Group submission relating to application SSD 5878

Sydney International Convention, Exhibition and Entertainment Centre Precinct
Mixed use Development in the Southern Haymarket Precinct (Concept Proposal) (SSD)

Figure 5.3. Building heights site diagram

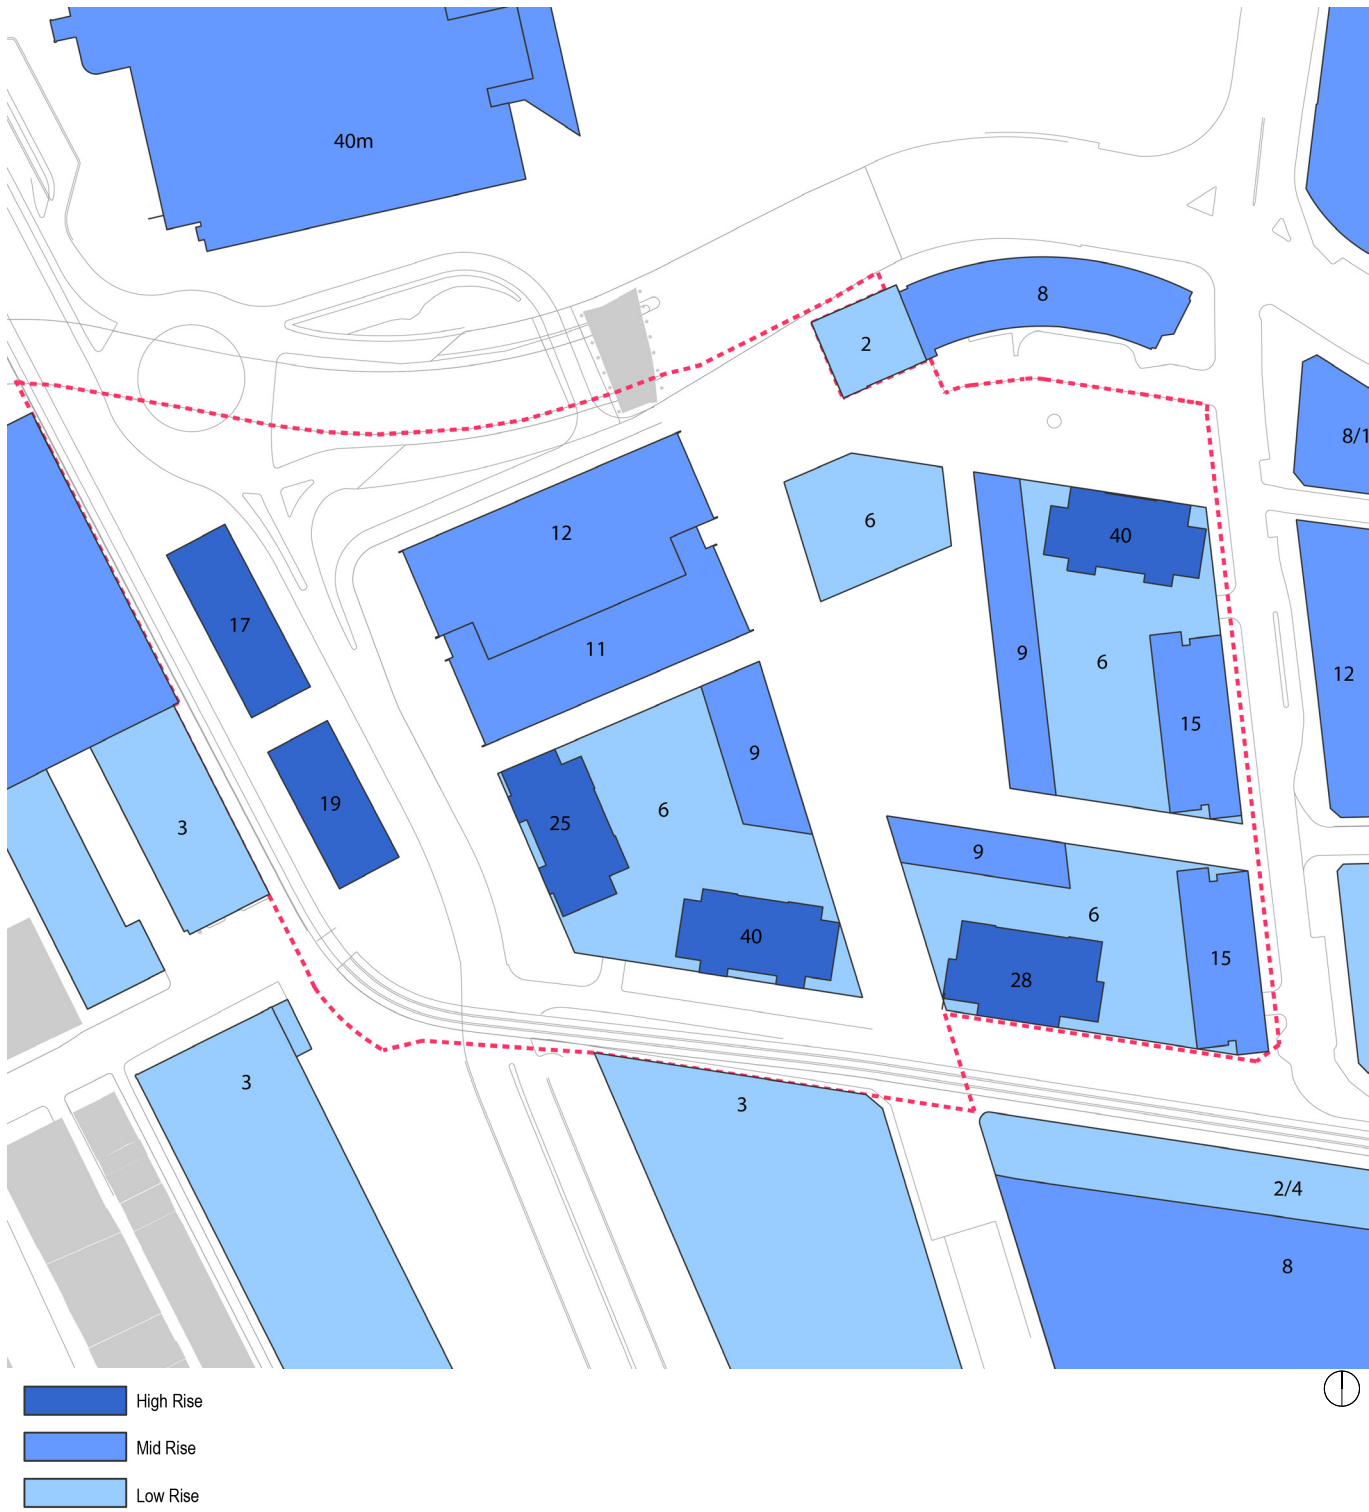
Each of the nine buildings has a proposed depth greater than the maximum 18 metres specified in the Residential Flat Design Code, and the developer fails to address the specific criteria in the Code under which the maximum may be exceeded.

The proposed building depths of the nine buildings are given in section 5.6.4 on page 88 of the EIS. They range from 19 metres to 24 metres.

It can be seen that each of the nine buildings has a proposed depth greater than the 18 metre guideline. The largest excess is 6 metres, which is 33% above the 18 metre guideline, but which the EIS describes as being a "relatively minor variation".
